25/03/2022

**ESR Horsley Logistics Park-Mod-4 (SSD-10436-Mod-4)  
Request for additional information**

The Department has undertaken a further review of the Applicant's response submitted on 23 March 2022 and requires the following information:

Drawing Title:  
**Overall Landscape Master Plan**  
 DWG No:  
**SSD-01**

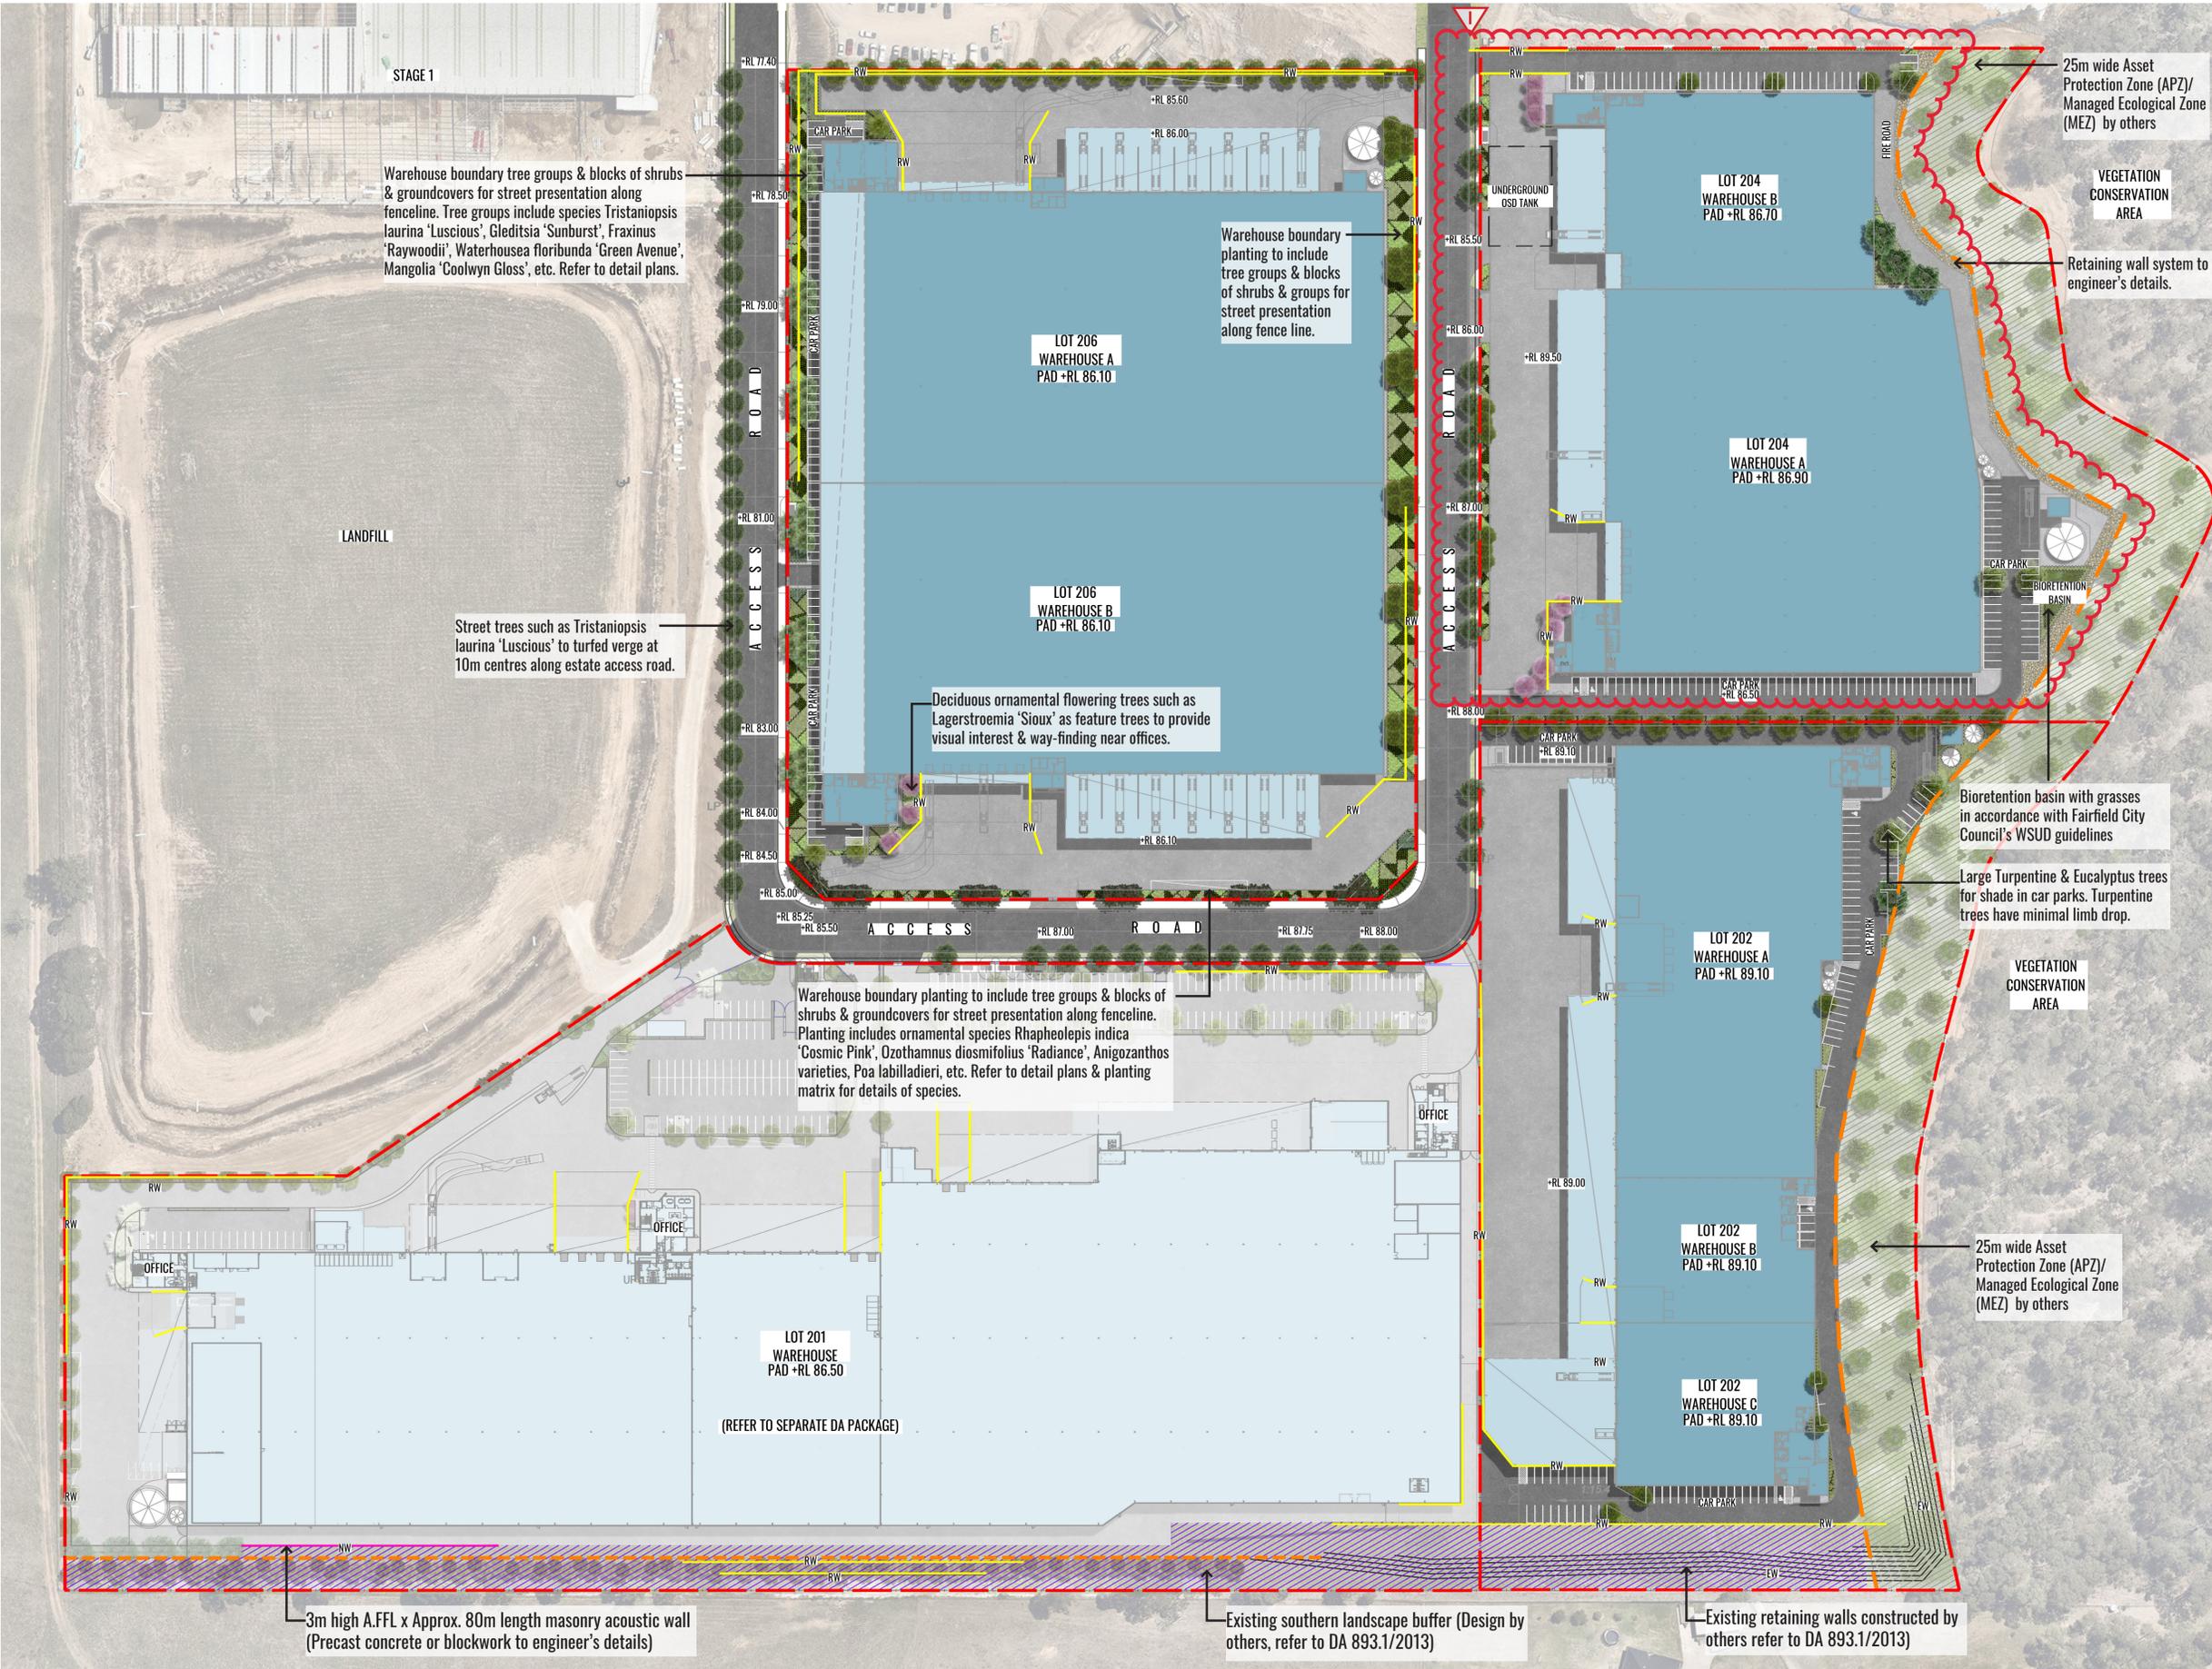
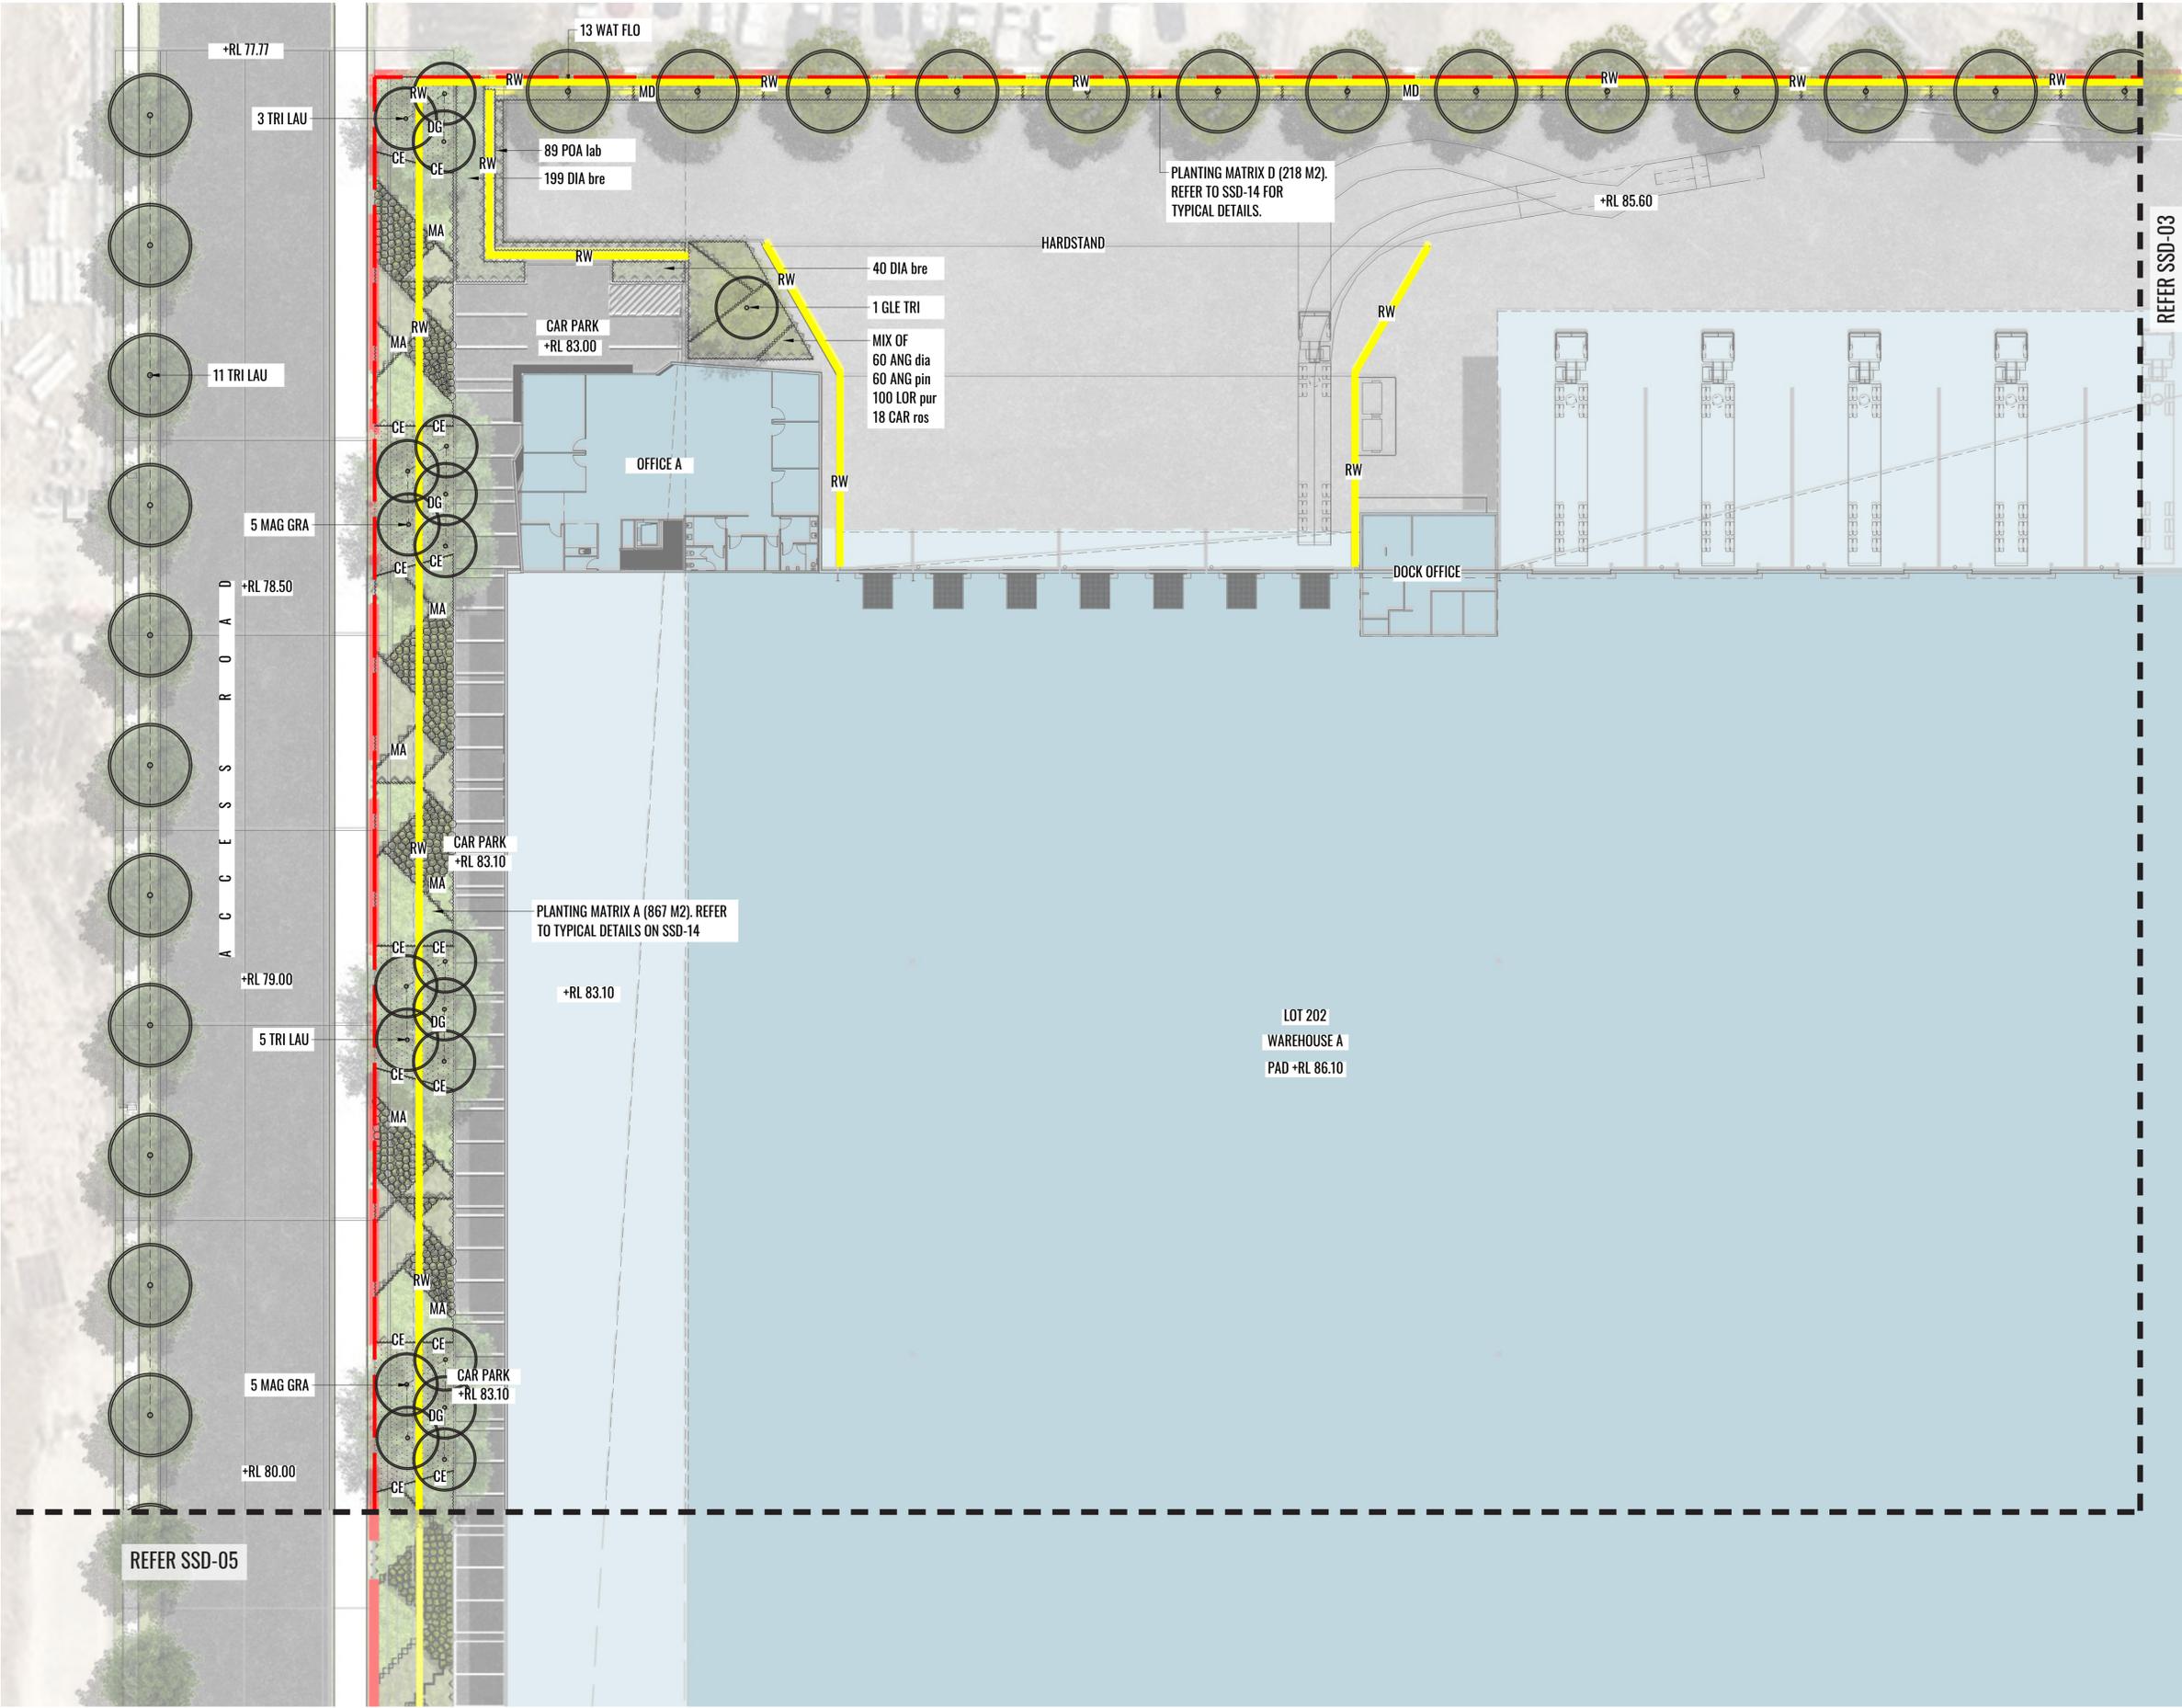
3. The RtS states due to minor layout revisions proposed to Lot 204, minor changes are proposed to the approved landscaping. It is unclear if this statement refers to the number of plantings proposed, the configuration or total area of landscaping for Lot 204. Clarification on this point is requested.

Figure 4 | Proposed HLP Master Plan

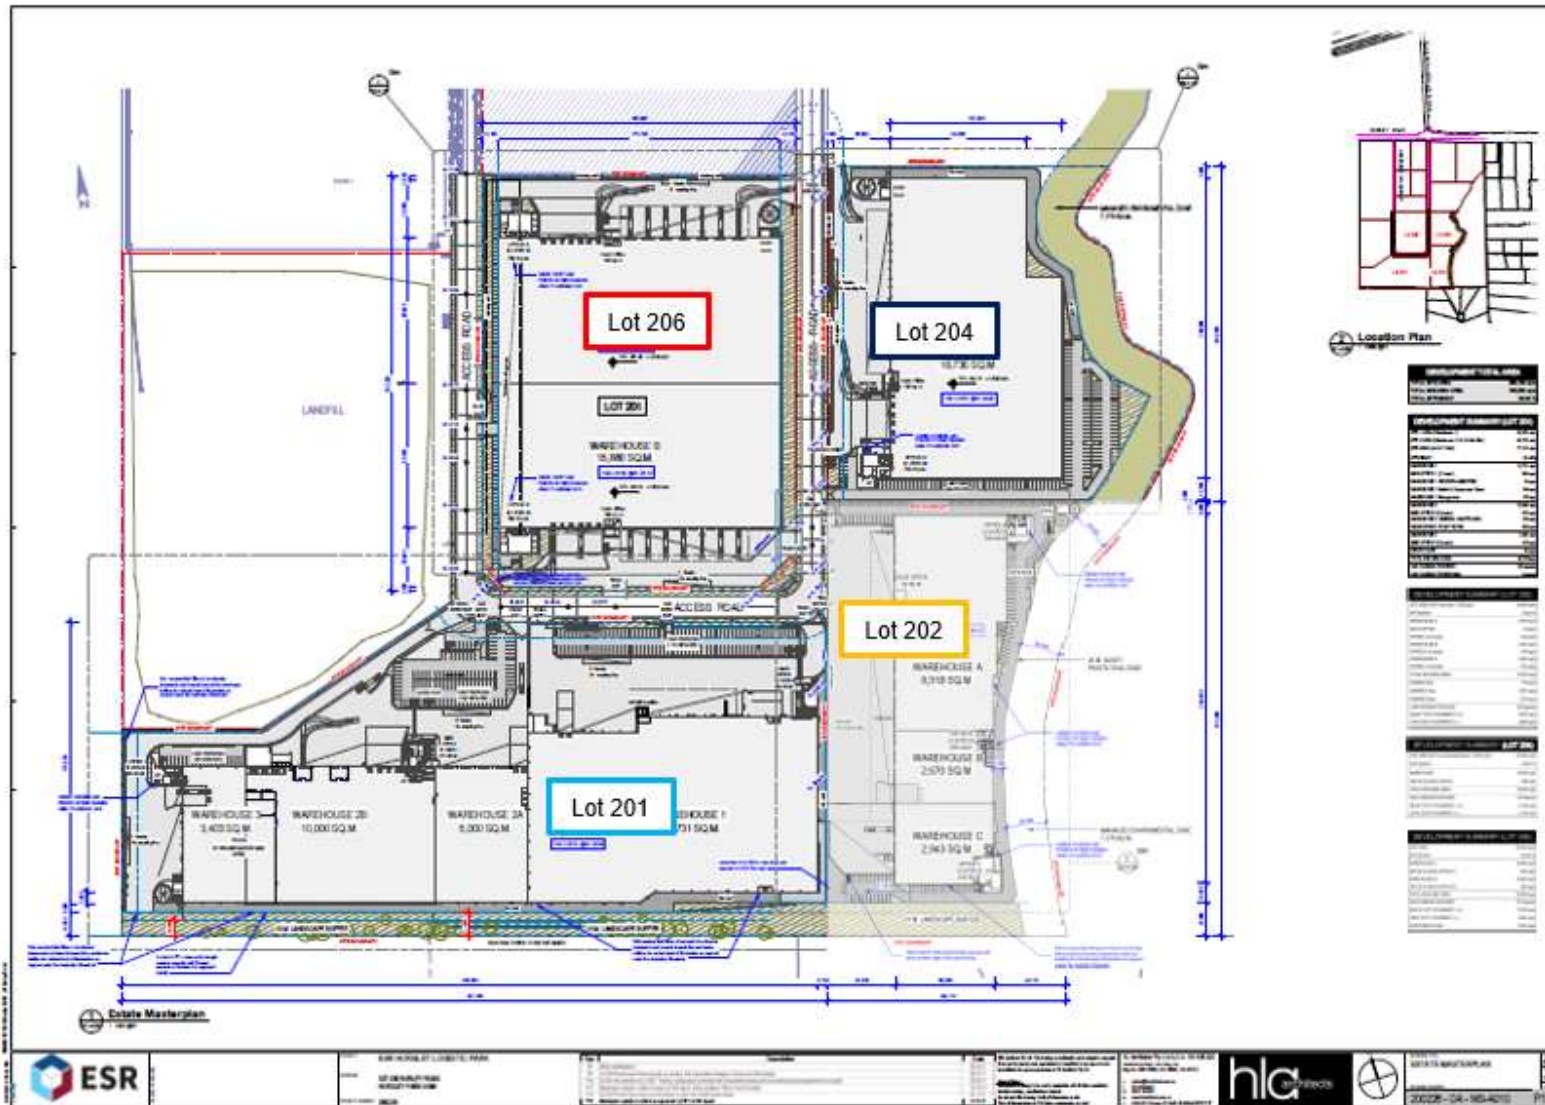
2. There are inconsistencies between the proposed and approved Estate Master Plan (MP):
  - i. the proposed MP revision is 12, the approved MP revision number is 14 (SSD-10436-Mod 5)
  - ii. the revision description in the footer does not include all revisions provided in version 14
  - iii. the total building area proposed results in an increase of 173m<sup>2</sup>:
    - 109, 592m<sup>2</sup> (approved SSD-10436-Mod 5)

- 109,765m<sup>2</sup> (proposed)
- This does not correlate with the above details within the Modification Report.
